**Our ref:** RA/2023/145899/02-L01  
**Your ref:** 2023/91441

**CHANGE OF USE AND ALTERATIONS TO FORMER CHURCH (B8-STORAGE) TO 9 RESIDENTIAL UNITS (C3) AND FORMATION OF CAR PARK (LISTED BUILDING WITHIN A CONSERVATION AREA) – 31 CHAPEL HILL, LINTHWAITE, HUDDERSFIELD, HD7 5NJ**

We have reviewed the Main River Culvert Condition Note prepared by Dudleys Consulting Engineers Ltd referenced 23345 and dated 6 September 2023.

**Drawing:**  
 Proposed  
 Site Plan

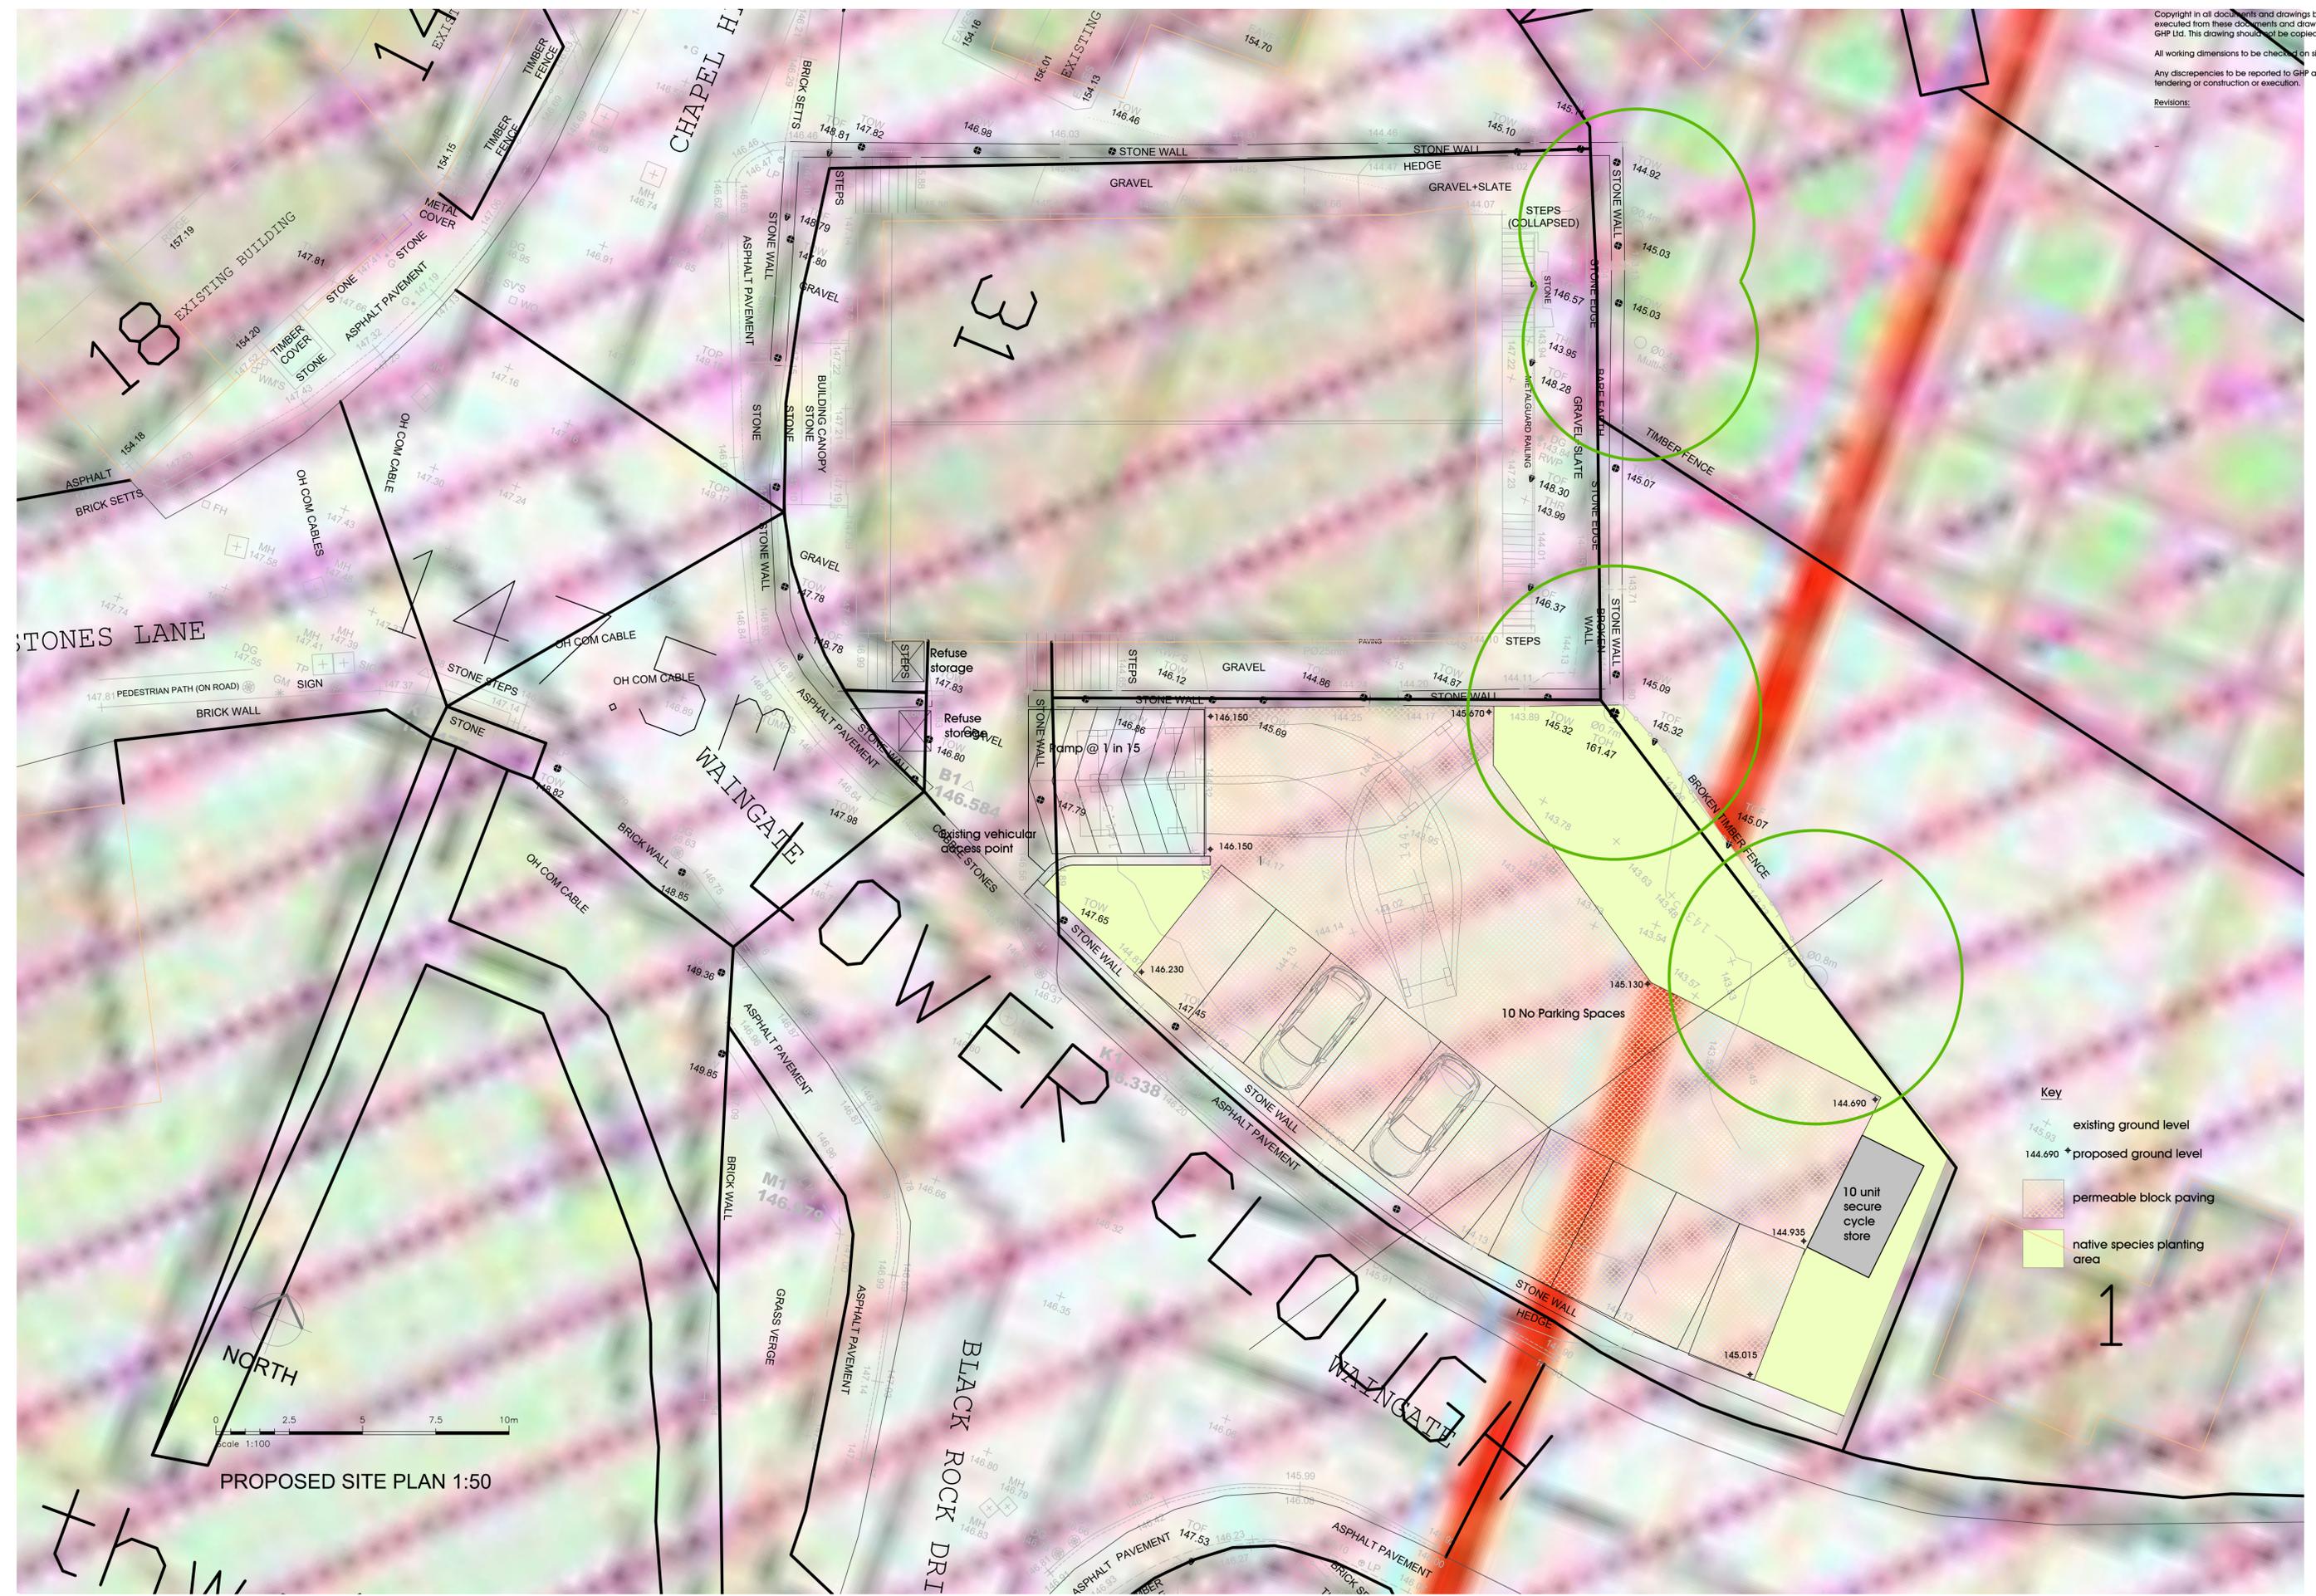
We maintain our objection to this application as it involves building near a culverted main river. As submitted, it is unlikely that we would grant a flood risk activity permit for this application.

The proposed development may adversely affect the construction and stability of the culvert which will compromise its function. The proposal could therefore increase the risk of flooding to surrounding communities, including Linthwaite. We note the justification for not opening the culvert in this location and accept this.

Further evidence must be provided to demonstrate that the proposed development will have no impact on the structural stability of the culvert. A CCTV report or similar of the culvert interior should be carried out to prove the culvert integrity is constant for the length of the site. Should this identify any further works needed to the culvert, further structural integrity assessments and calculations must be provided, together with a plan for reconditioning the culvert.
